Subject: **Request for Modification of 404 Individual Permit, 401 Water Quality Certification Permit, Tar-Pamlico Buffer Authorization, and CAMA Major Development Permit** for the proposed Washington Bypass. US 17 From South of SR 1149 (Price Road) to North of SR 1509 (Springs Road). TIP Number: R-2510B, Federal Aid Project MAF-75-3(26). Debit \$475 for WQC Modification from WBS Element No. 34440.1.1

Reference: USACE Action ID 199301143
DWQ Project No. 050785, WQC No. 3527
CAMA Permit No. 29-07

Summary of Changes

PROJECT REFERENCE NO. R-2510B	SHEET NO. 7.5
WETLAND IMPACT SHEET REVISED 4/19/07	
ENGLISH

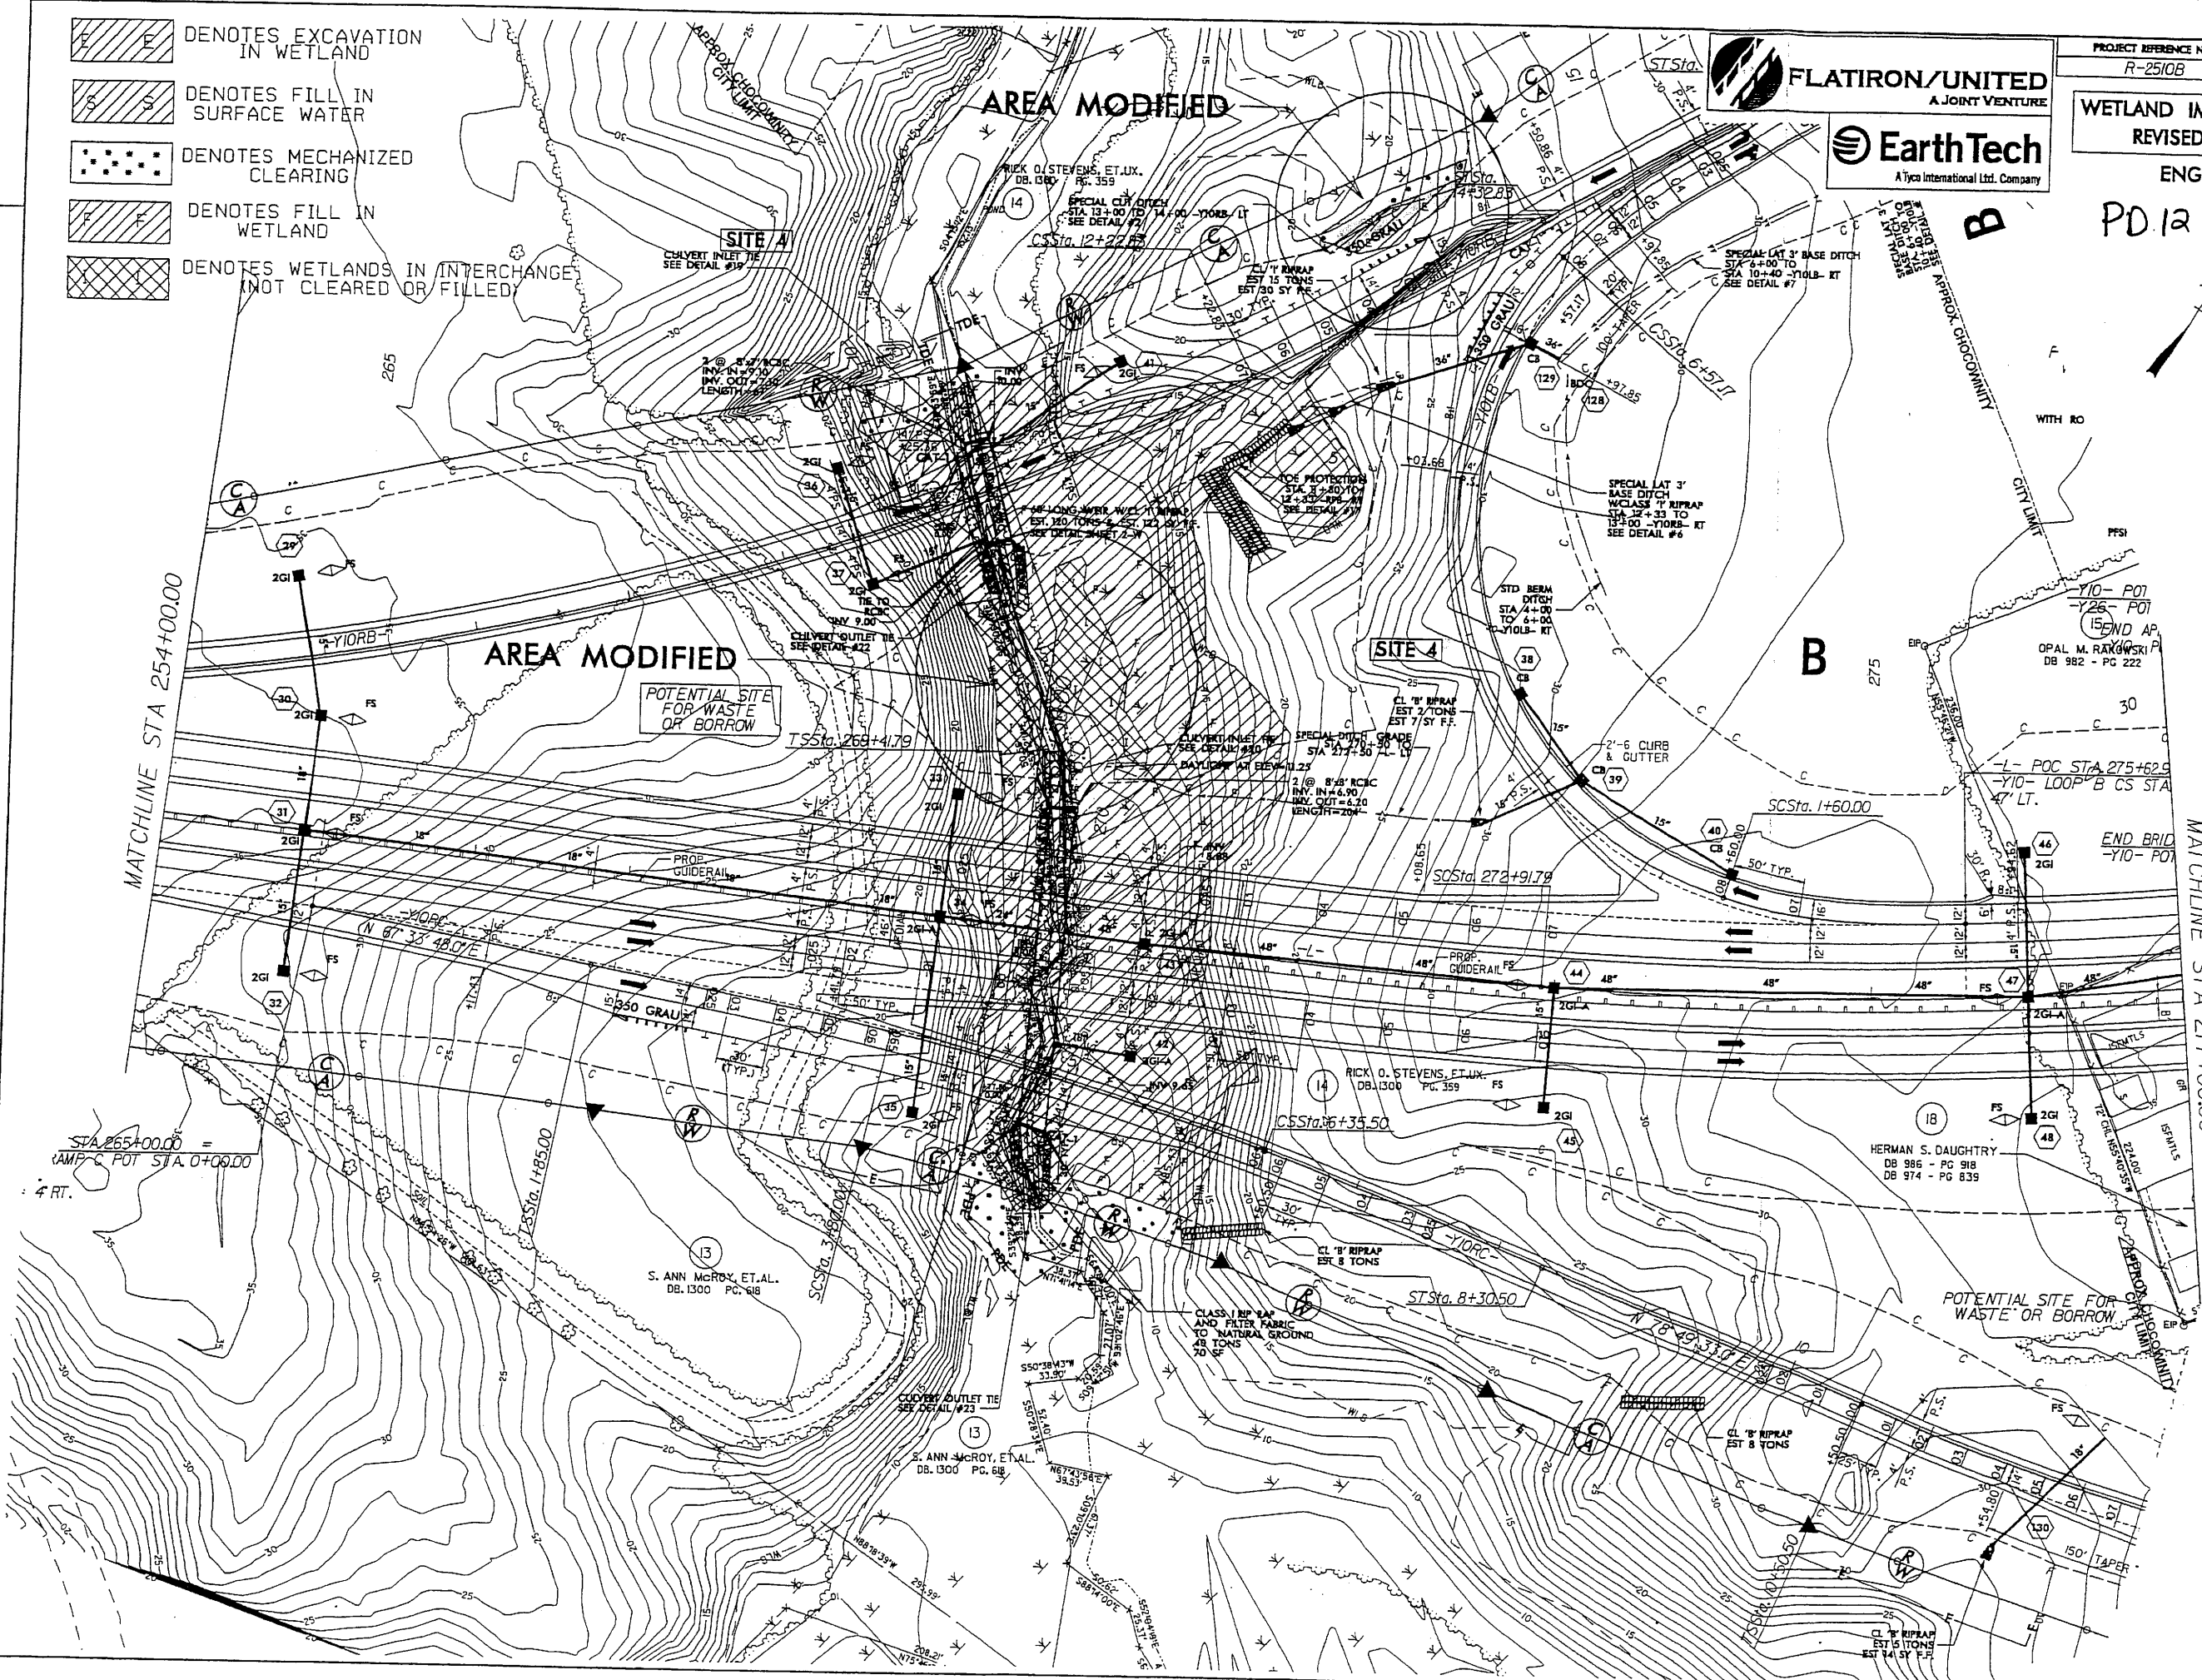
This application addresses impacts at Sites 4 and 9. There is no change in the amount of wetland impacts, however, there is a change to the types of impacts. Excavation in wetlands has increased by 0.03 acre and mechanized clearing has decreased by 0.03 acre. There is an increase of 1,522
